**Albuquerque Studios Master Plan
Development**

Traffic Impact Study

HT#R16DA3006A
Received
1/12/2022

January 4, 2022

Figure 13
Buildout With Project AM Peak Hour Volumes
23

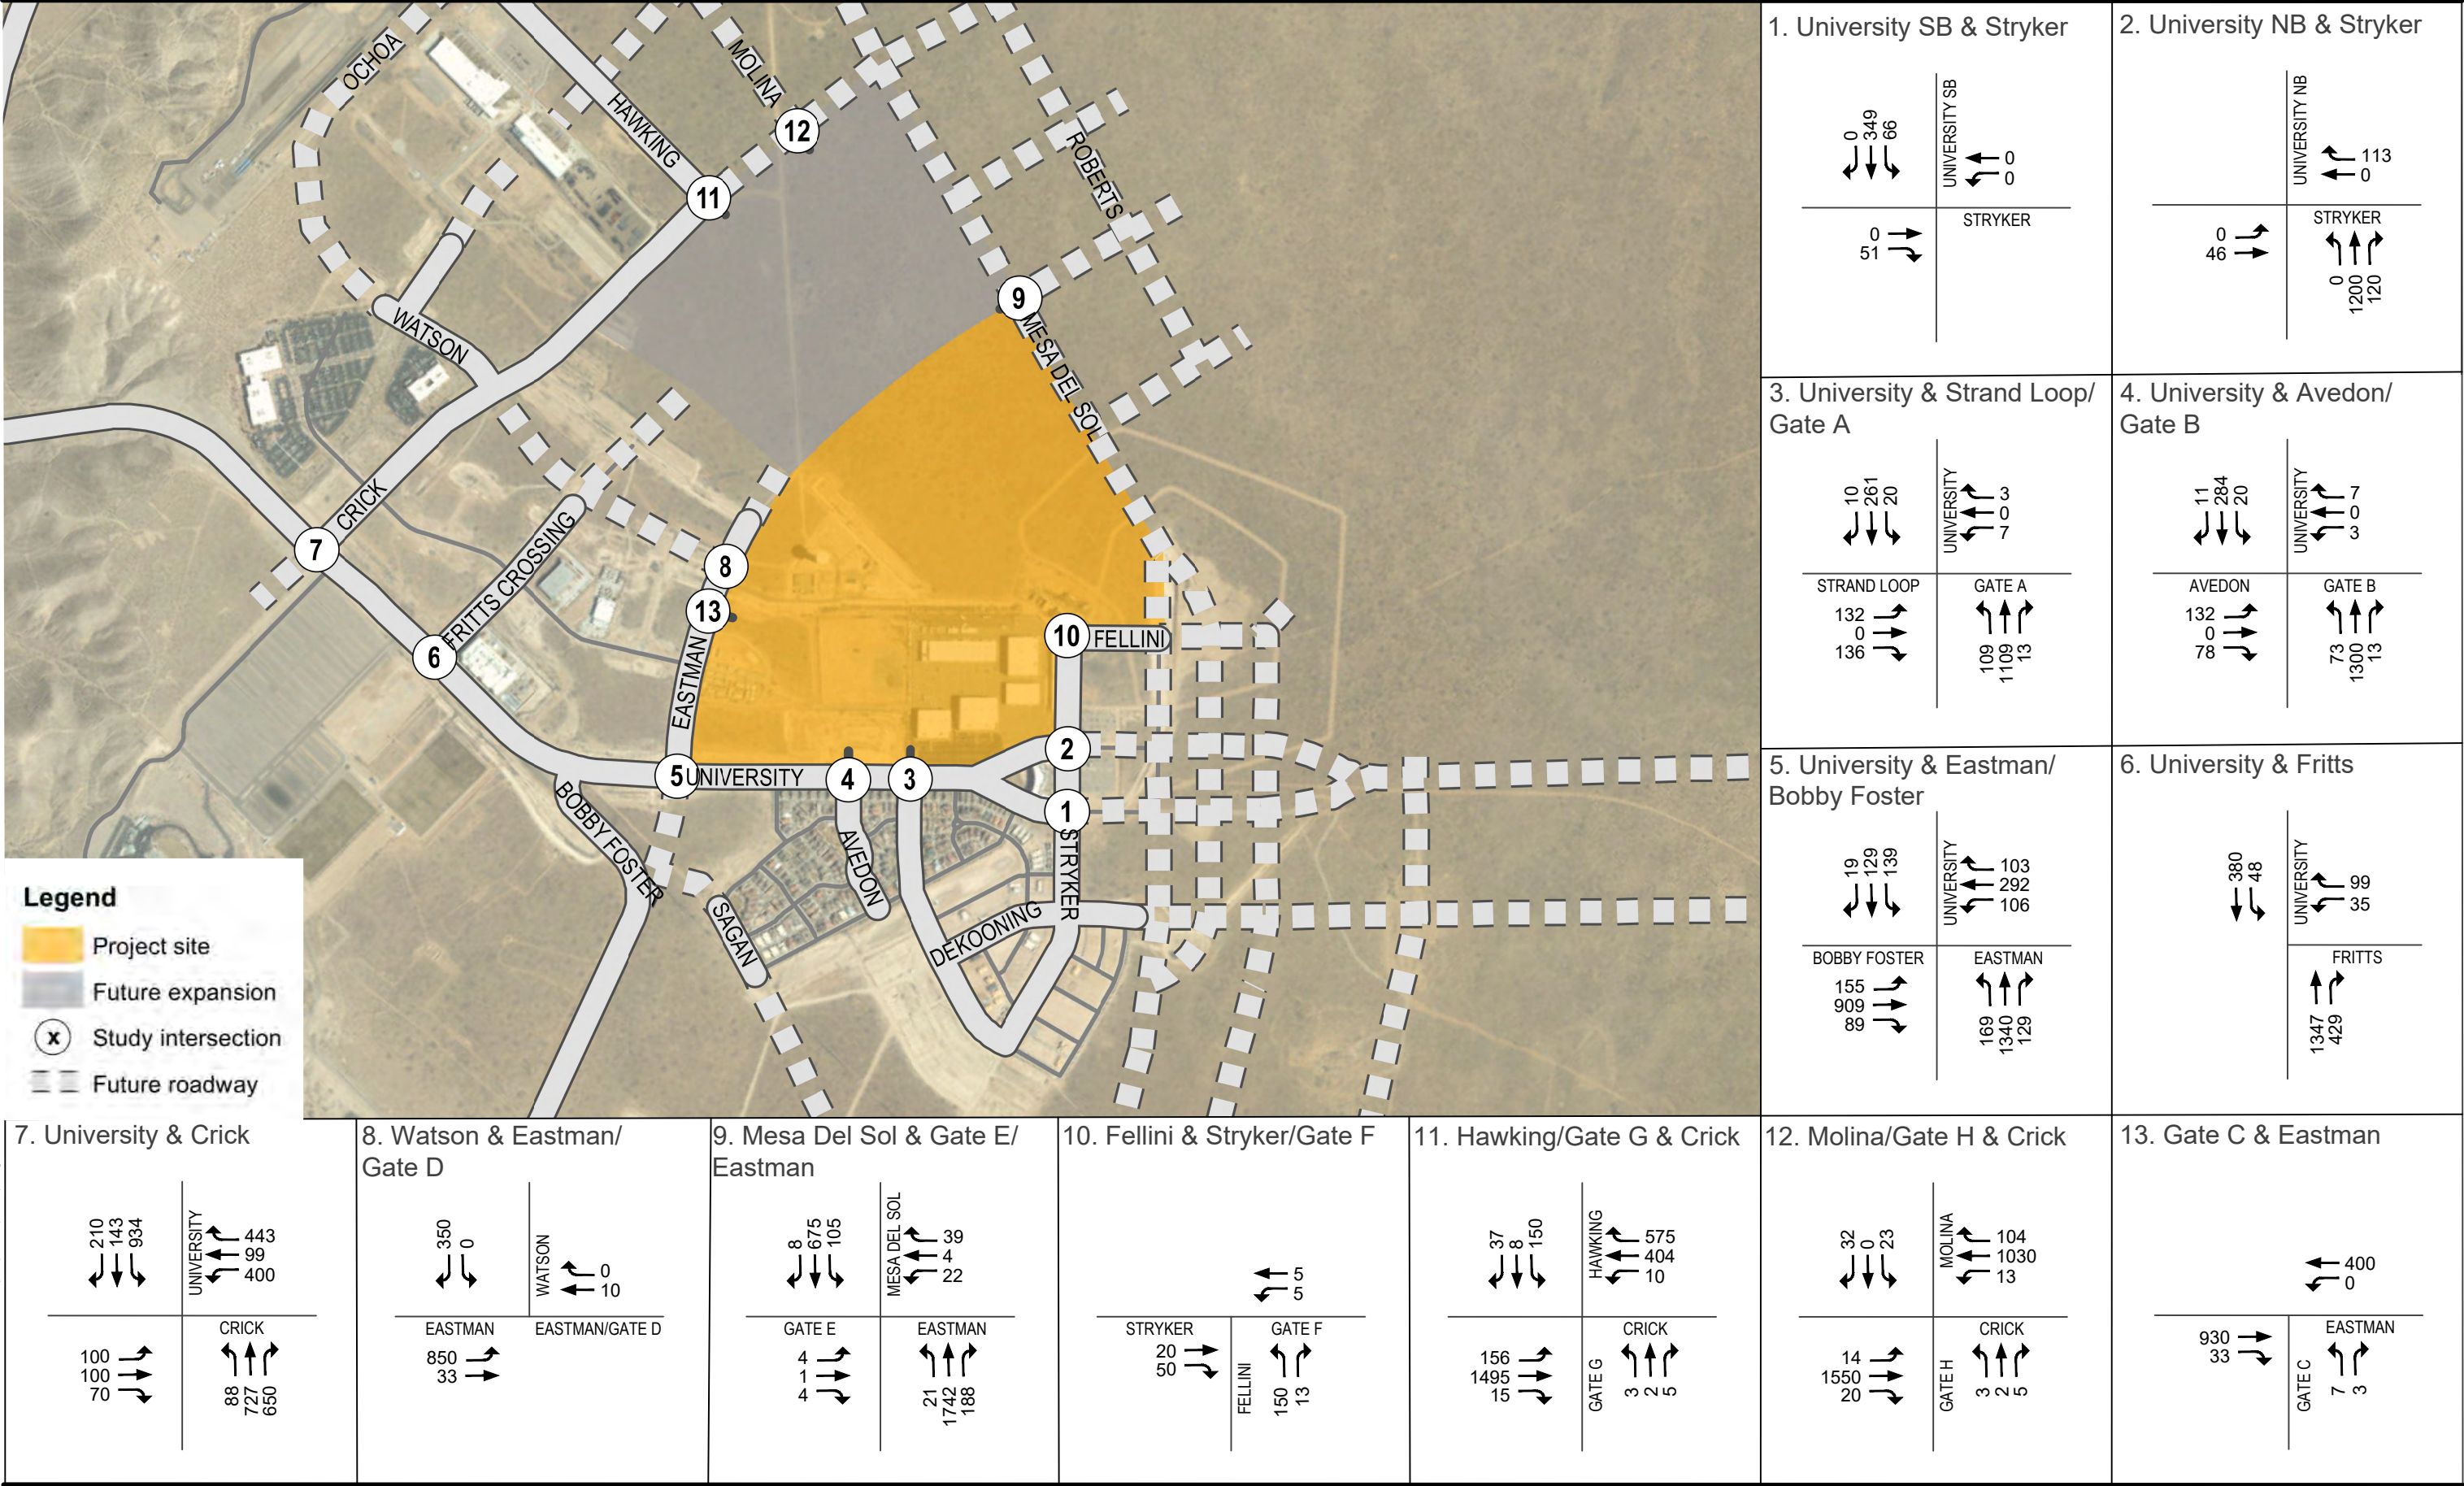
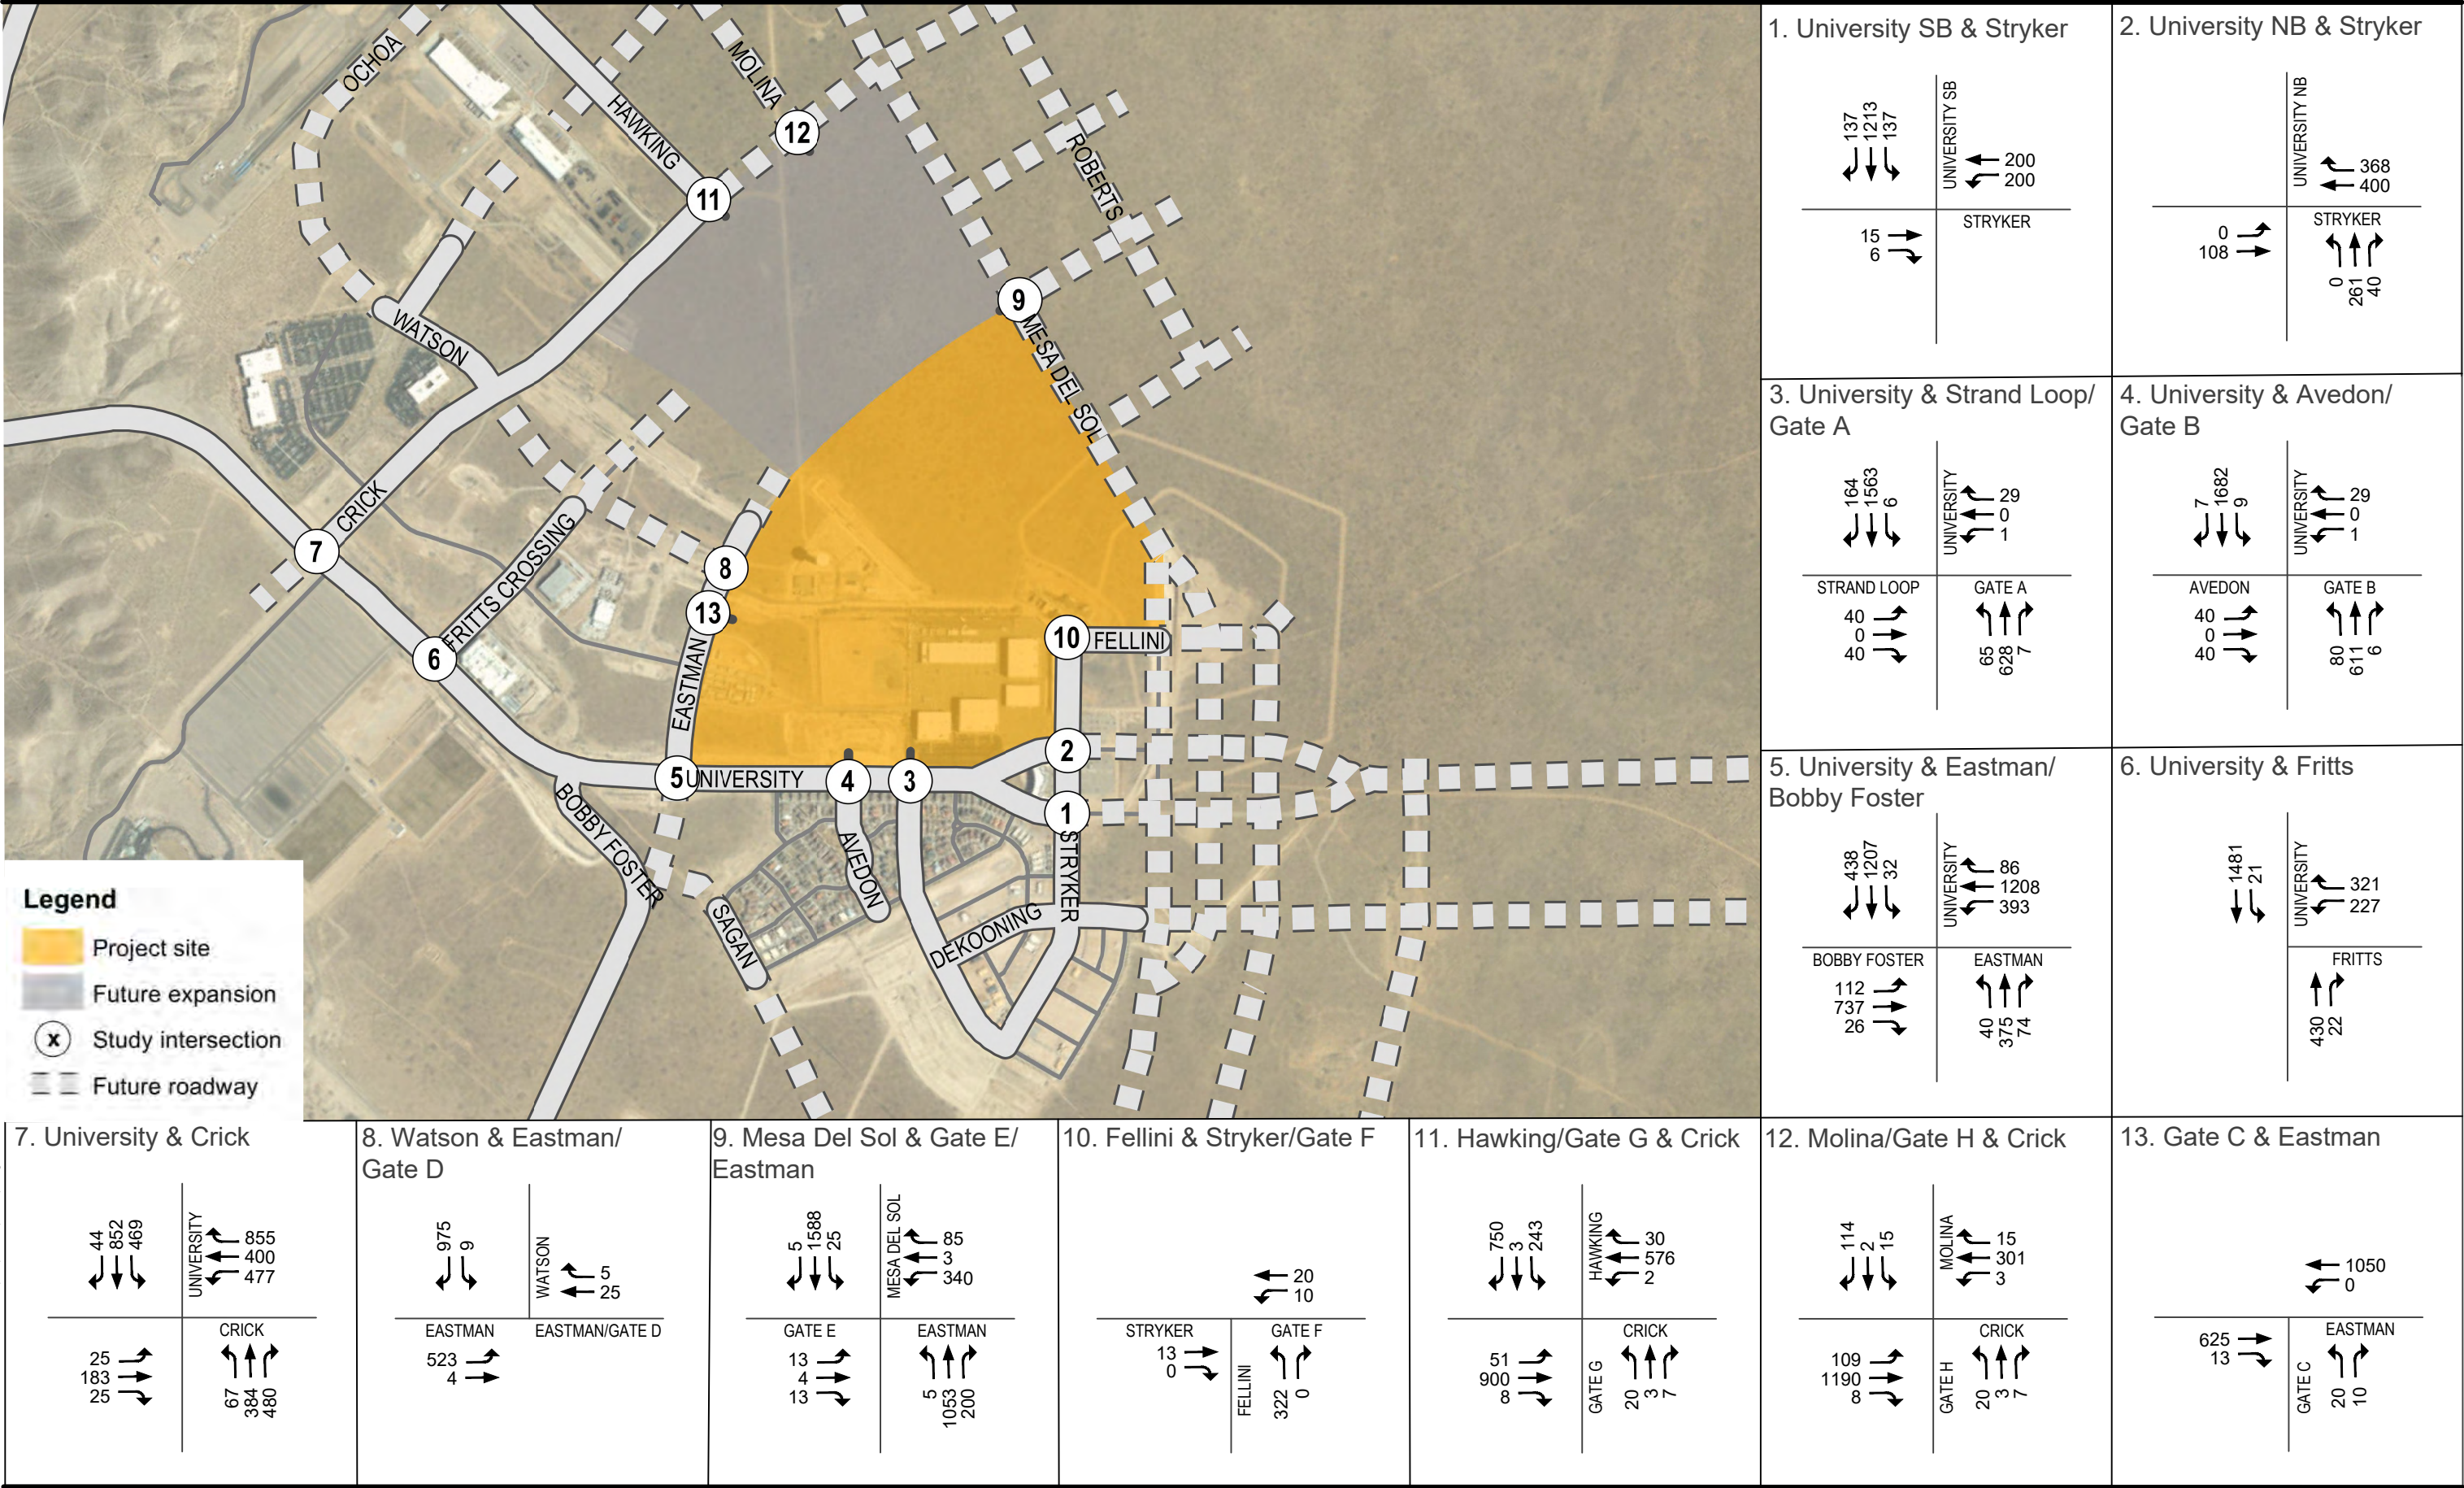
Intersection 10 Hawking/Fellini/Stryker: Determine where the traffic is coming from and who is responsible?

- Stryker EB right to SB Fellini - (Bypass Traffic - not Netflix Traffic) – to incorporate a left turn lane
- Fellini NB left to Stryker - (Netflix Traffic) – to incorporate a right-turn lane
- Provide cross sections to show constraints that need to be resolved to increase the street width as needed

- Stryker EB right to SB Fellini - (Bypass Traffic - not Netflix Traffic) – not feasible due to section constraints
- Fellini NB left to Stryker - (Netflix Traffic) – not feasible due to section constraints
